The Drovers Solar Farm

Statement of Common Ground (SoCG) with Environment Agency

PINS reference: EN0110013

Document reference: APP/5.13 (Original)

Drawing file: published-documents / EN0110013-000144-6.3 ES Figure 12.13 Work No.2 Piling Locations within CSA for Maximum Groundwater Level.pdf

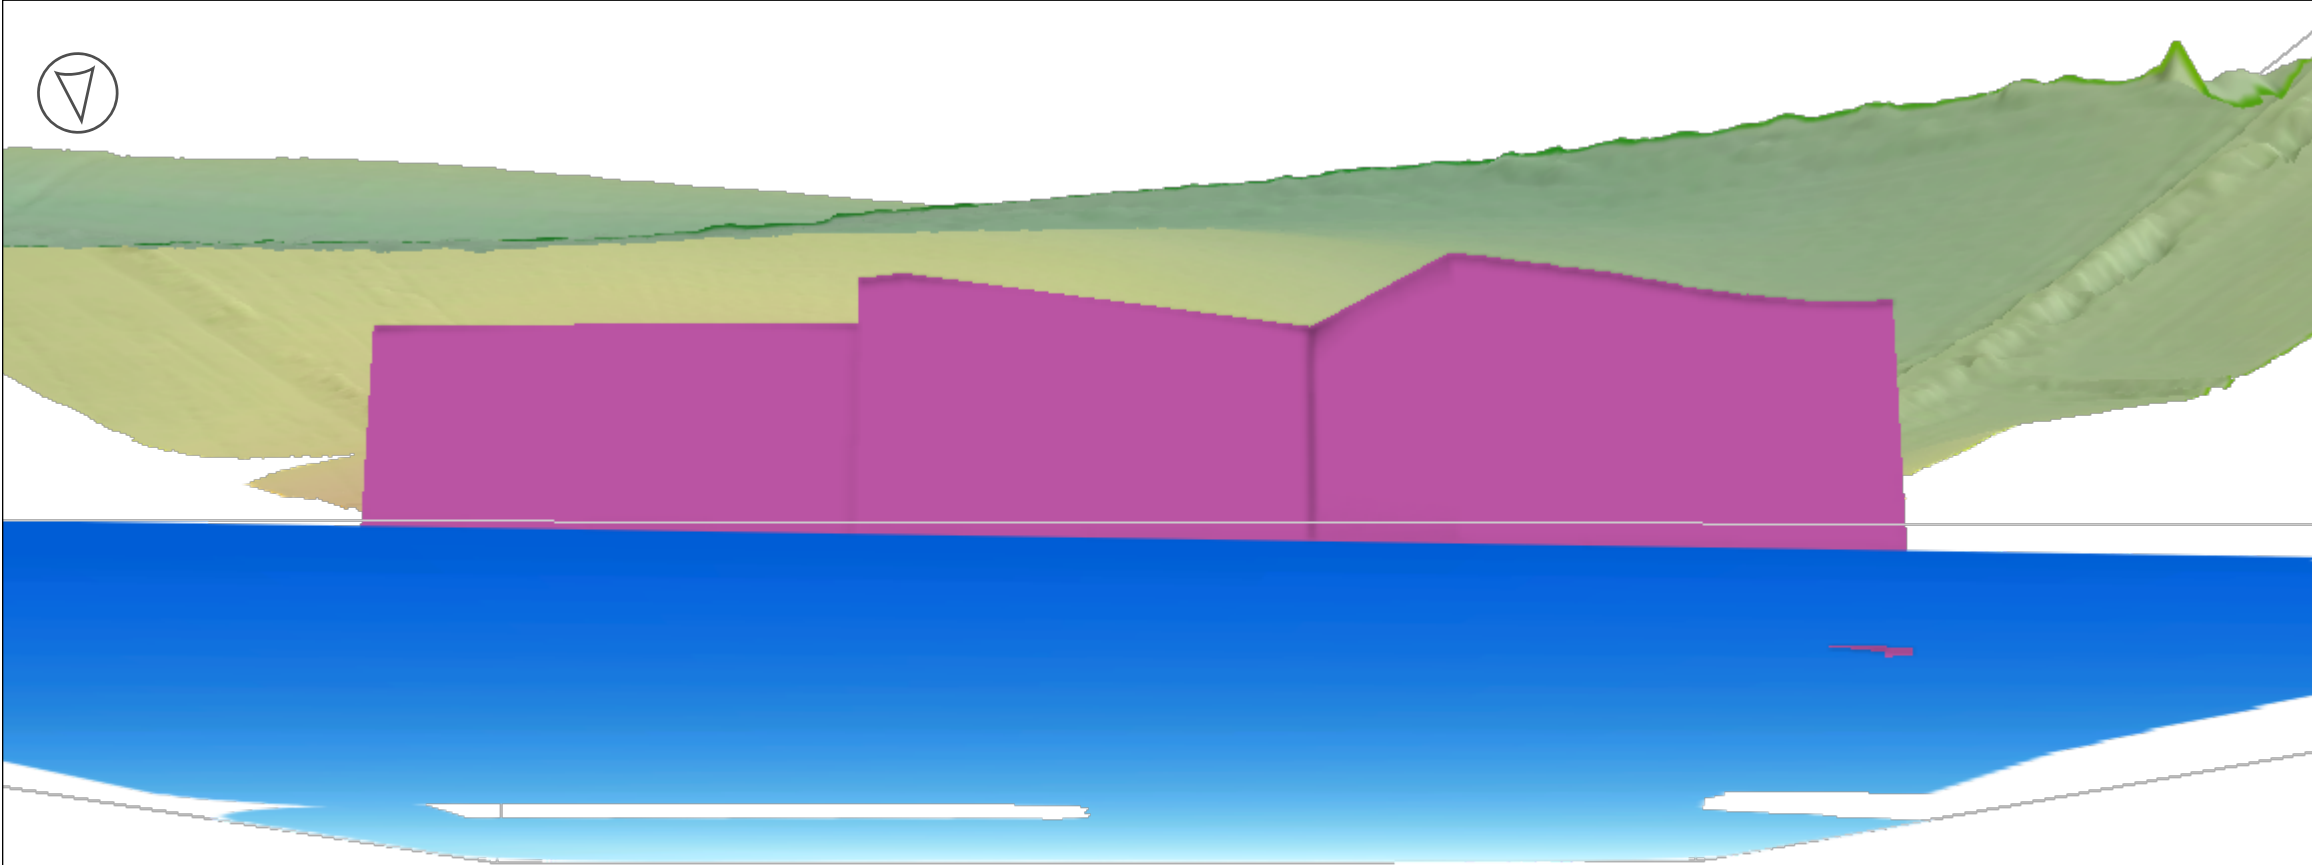
Reference	EA Issue Reference	Topic	Consultee’s Position	Applicant’s Position	Status
2-1	EA05	Maximum Foundation Extents	<p>Figure 12.13 Work No.2 Piling Locations within CSA for Maximum Groundwater Level [APP-127]</p> <p>Figure 12.14 Work. No 3 Piling Locations within CSA for Maximum Groundwater Level [APP-128]</p> <p>Figure 12.15 Work No. 4 Piling Locations within CSA for Maximum Groundwater Level [APP-129]</p> <p>Figure 12.16 Maximum Foundation Extents for Minimum Groundwater Level [APP-130]</p> <p>Issue: Figures 12.13 to 12.16 do not clearly show the orientation of each 3D model view, and the elevation of the maximum extent of foundations is not given.</p> <p>Impact: Difficulty in interpreting figures.</p> <p>Solution: Revise figures to more clearly define the area represented in the drawings, including view orientation, and the maximum foundations extent should be shaded to show elevation values. The model should be updated to inform detailed foundation design, based on site specific survey and monitoring data.</p> <p>Additional Comments: Use of inconsistent terminology may also result in confusion.</p>	<p>Figures 12.13 to 12.16 of ES Chapter 12: Water Resources [APP-061] were used to illustrate the maximum groundwater elevation surface across the Core Study Area and identify where proposed foundation depths could theoretically intercept shallow groundwater under worst-case conditions. The figures also demonstrate at a concept level where piling may be required depending on foundation design.</p> <p>The following changes will be made at a future Deadline to aid the EA’s interpretation:</p> <ul style="list-style-type: none"> • Addition of orientation labels or description • Elevation shading to show mAOD values for the maximum groundwater elevation surface and foundation extent surface • Highlight areas where foundations intersect or exceed groundwater elevation surfaces; and • Figures and text refer to groundwater elevation (mAOD) rather than groundwater level to increase clarity 	Medium

<p>Figures 12.13 to 12.15 are titled to show the anticipated extent of piling in comparison with the maximum groundwater level. In the context of the data presented, the maximum groundwater level in mAOD represents the shallowest extent and therefore worst-case condition for groundwater. For clarity the report should preferably refer to groundwater 'elevation' (in mAOD) as is represented within the figures rather than 'level', which could be misinterpreted as relative to ground level rather than Ordnance Datum.</p> <p>Figure 12.16 shows the minimum (i.e. deepest) groundwater elevation (i.e. best case) in relation to anticipated piling depth. Although this is useful information, this could potentially be misinterpreted by the reader as presenting a combined overview of the information provided in Figures 12.13 to 12.15.</p>	<p>between absolute elevation and depth below ground.</p> <p>The Applicant agrees that the conceptual model present is not the final tool for foundation design, but rather to provide a screening-level assessment of groundwater conditions and to identify areas needing piled or shallow foundations and will be aligned with EA regional groundwater understanding (NEAC model). The Design Principles, Parameters Commitments [APP/5.8.1] will be updated at a future deadline to commit to foundations not directly interacting with groundwater.</p>

Drawing file: published-documents / EN0110013-000634-6.3.1 ES Figure 12.10 Groundwater Flow Directions from NEAC Groundwater Model.pdf

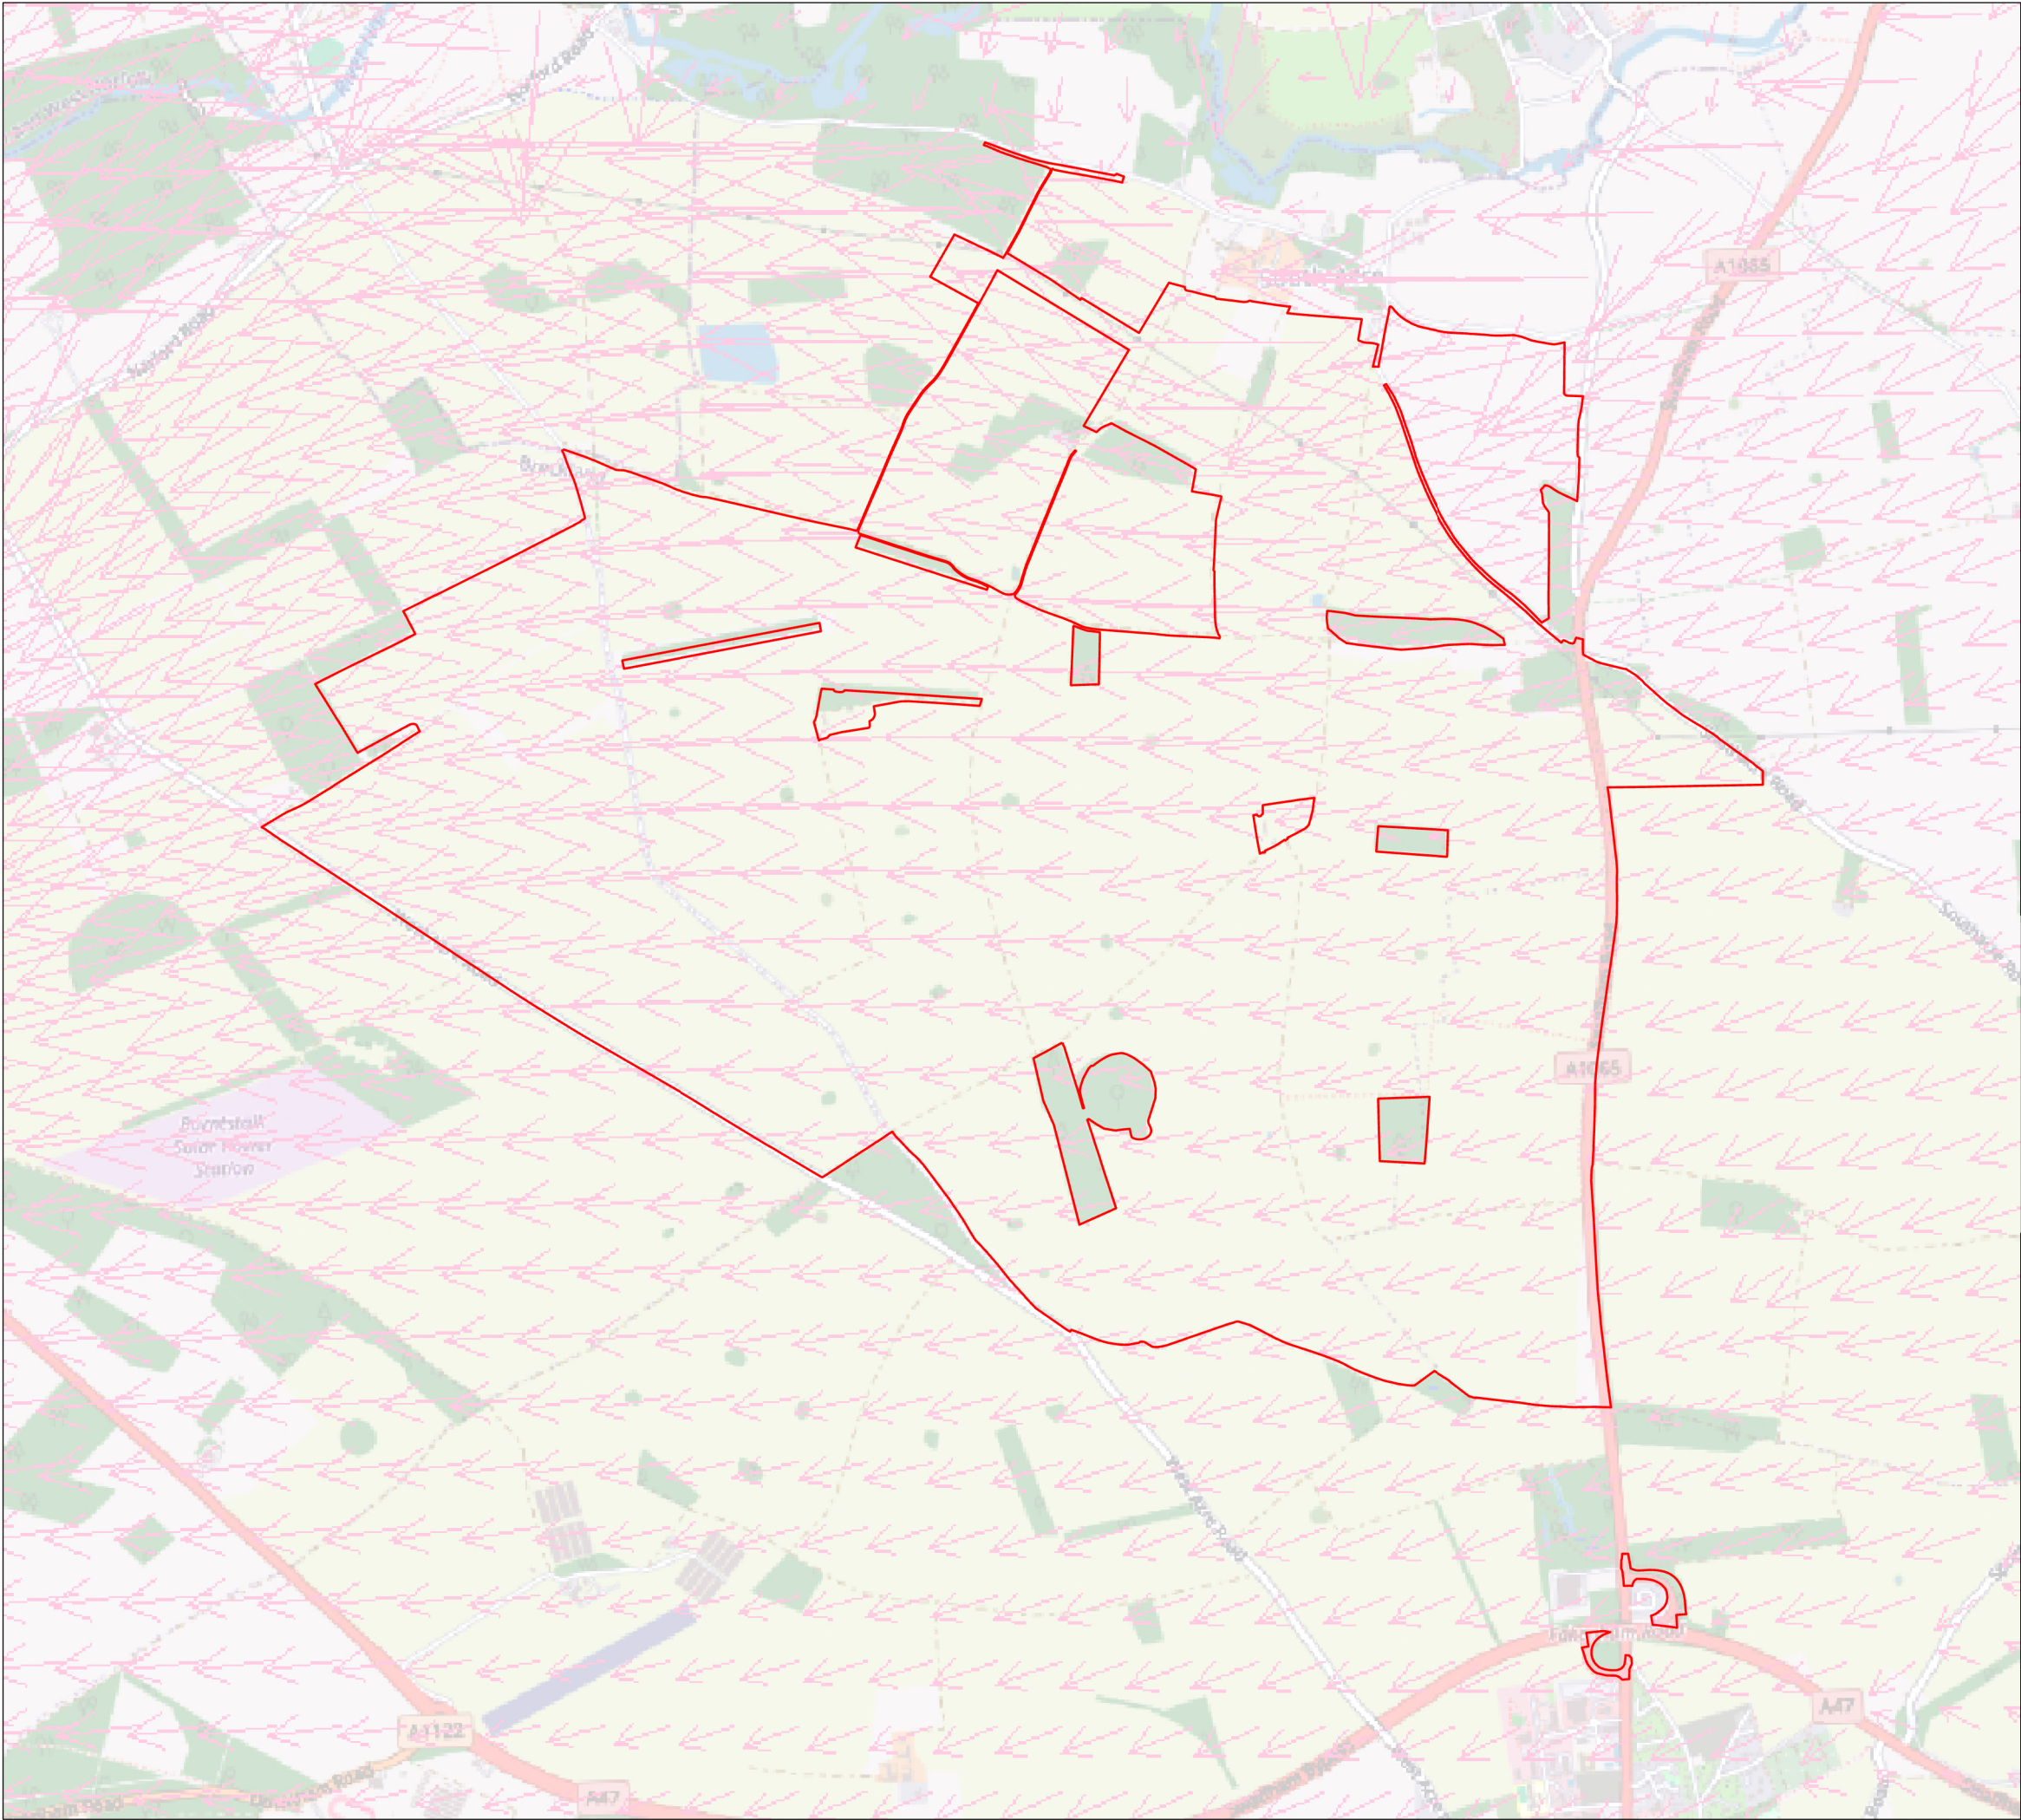
<p>minimum or maximum groundwater depth model data shown in</p> <p>Figure 12.8 or 12.9 respectively, or if it represents a separate dataset.</p>		
1-4	EA04	Groundwater Flow Direction	<p>Figure 12.7 3D Representation of Groundwater [APP-121]</p> <p>Figure 12.8 Minimum Static Groundwater Level Depths within CSA [APP-122]</p> <p>Figure 12.9 Maximum Static Groundwater Level Depths within CSA [APP-123]</p> <p>Figure 12.10 Groundwater Flow Patterns [APP-124]</p> <p>Figure 12.11 Private Water Supplies Locations [APP-125]</p> <p>Figure 12.12 Drinking Water Protected Area [APP-126]</p> <p>Figure 12.13 Work No.2 Piling Locations within CSA for Maximum Groundwater Level [APP-127]</p> <p>Figure 12.14 Work. No 3 Piling Locations within CSA for Maximum Groundwater Level [APP-128]</p> <p>Figure 12.15 Work No. 4 Piling Locations within CSA for Maximum Groundwater Level [APP-129]</p> <p>Figure 12.16 Maximum Foundation Extents for Minimum Groundwater Level [APP-130]</p>	<p>The Environment Agency’s comment on groundwater flow is noted.</p> <p>The Environment Agency’s NEAC model outputs and BGS 1976 hydrogeological map indicate a regional westward flow component towards the Marham abstraction. The north-northeast flow vectors shown in Figures 12.7 to 12.16 to ES Chapter 12: Water Resources [APP-061] are therefore more likely to represent localised topographic influences near the River Nar valley margin than the regional groundwater flow regime within the Chalk Principal Aquifer.</p> <p>The groundwater surfaces present in ES Figures 12.7 to 12.16 to ES Chapter 12: Water Resources [APP-061] are intended to illustrate relative groundwater depth beneath proposed infrastructure locations and identify where piling or foundations may interact with perched or shallow groundwater. This would highlight zones where interception risk across the Work Nos. 1 to 4 during construction could occur. They were not intended to be used as a regional groundwater flow model.</p> <p>Paragraphs 12.6.37 and 12.6.38 of ES Chapter 12: Water Resources [APP-</p>	Medium

<p>Environmental Statement Chapter 12: Water Resources [APP-061], Sections 12.6.9, 12.6.37 and 12.6.38</p> <p>Issue: Estimated groundwater flow direction across most of the draft Order Limits area is indicated to be toward the north-east, north or northwest, approximately following local topography.</p> <p>Impact: Groundwater flow direction as indicated in Figures 12.7 to 12.16 may be inaccurate.</p> <p>Solution: Claims such as that made in Sections 12.6.37 and 12.6.38 regarding potential groundwater interception should be revised and new evidence, preferably across multiple lines, sought to support them. Intrusive investigation to measures groundwater level with empirical evidence is highly recommended.</p> <p>Additional Comments: The majority of the draft Order Limits area is shown to be underlain directly by Chalk Principal aquifer, and according to Chapter 12 Section 12.6.9, trial trenching activities in the vicinity of the proposed BESS and substation sites did not encounter superficial deposits. The draft Order Limits area lies within Zone 1 and Zone 2 of a groundwater SPZ for a potable water abstraction at Marham, located to the west of the draft Order Limits area. This indicates that groundwater within the Principal aquifer in this area is anticipated to</p>	<p>[061] will be updated at a future Deadline to remove any implied statements of groundwater flow direction across the Order limits and present the Applicant's findings are local-scale interpretations. Reference to the Environment Agency's NEAC model and BGS hydrogeological mapping in regard to regional groundwater flow will be made to consolidate the conceptual groundwater model of the Scheme.</p> <p>Paragraph 12.8.23 of ES Chapter 12: Water Resources [APP-061] commits to installing boreholes within the Order limits to monitor groundwater levels prior to construction to ensure that construction activities such as HDD and foundations do not occur when groundwater levels are high enough to interact with the activity.</p> <p>The Applicant has requested the Environment Agency's NEAC model and this will be used to further refine groundwater elevations within the Order limits at a subsequent Deadline, noting that <i>"the Applicant's estimations are within a similar range of values for most of the Study Area"</i>. As such, the Applicant does not anticipate the outcome of ES Chapter 12: Water Resources [APP-061] to change.</p>

<p>migrate toward the abstraction point to some degree.</p> <p>A review of the 1976 British Geological Society (BGS) Hydrogeological Map of Northern East Anglia (British Geological Survey (BGS) large image viewer IIPMooViewer 2.0) indicates that the potentiometric groundwater upper surface within the Chalk principal aquifer in the vicinity of the site is locally northward toward the River Nar valley but more generally toward the west in the direction of the Marham public water supply abstraction. This is shown in the BGS map as ranging from approximately 30m Above Ordnance Datum (AOD) in the east to approximately 15m AOD in the west.</p> <p>The model outputs produced by the Applicant can be compared to the outputs for various hydrological scenarios available from the Environment Agency's North East Anglian Chalk (NEAC) model, a bespoke groundwater model using MODFLOW 5 which covers most of East Anglia.</p> <p>The outputs for a wet month Scenario (March 2001 – corresponding to the Applicant's 'worst-case' data usage of highest recorded levels) show very different groundwater contours and resultant flow directions compared with those produced by the Applicant. Flow in the Chalk is east-to-west in the NEAC model data, rather than south-to-north using the Applicant's techniques</p>

<p>derived from individual boreholes nearby. Northwards flow is present locally near the left bank of the Nar, but this reflects the topography close to the Nar intercepting the westerly flowing groundwater. If modelling will be used in the future, the Applicant is advised to consider groundwater flow on a more regional level rather than overfitting a model to a low number of interpolated datapoints. They may also choose to request model runs done on the Environment Agency's NEAC model which can run scenarios designed and paid for by the Applicant.</p> <p>Although the Applicant's estimations are within a similar range of values for most of the Study Area, the figures provided from their modelling should not be accepted as an accurate representation of subsurface groundwater elevation or flow direction.</p>		
1-5	EA12	Flood Risk - BESS	<p>Environmental Statement Appendix 12.2: Flood Risk Assessment [APP-170], Section 12.2.20</p> <p>Issue: Insufficient flood mitigation provided for BESS units.</p> <p>Impact: As currently proposed, BESS units may remain at risk of flooding where pluvial flood depths exceed 0.1m.</p> <p>Solution: Confirm BESS units will be appropriately raised above ground level. We</p>	<p>The Scheme has Work Nos. and does not have a detailed design at this stage. A detailed drainage plan will be provided once the detailed design of the Scheme has been progressed and finalised, following the issue of the DCO (if consented), as detailed within Section 12.4 of ES Appendix 12.2: Flood Risk Assessment [APP-170].</p> <p>If localised flood depths cannot be managed via the drainage strategy, ES Appendix 12.2: Flood Risk Assessment [APP-170] will be updated at a future deadline to confirm that BESS units will be appropriately</p>	Low
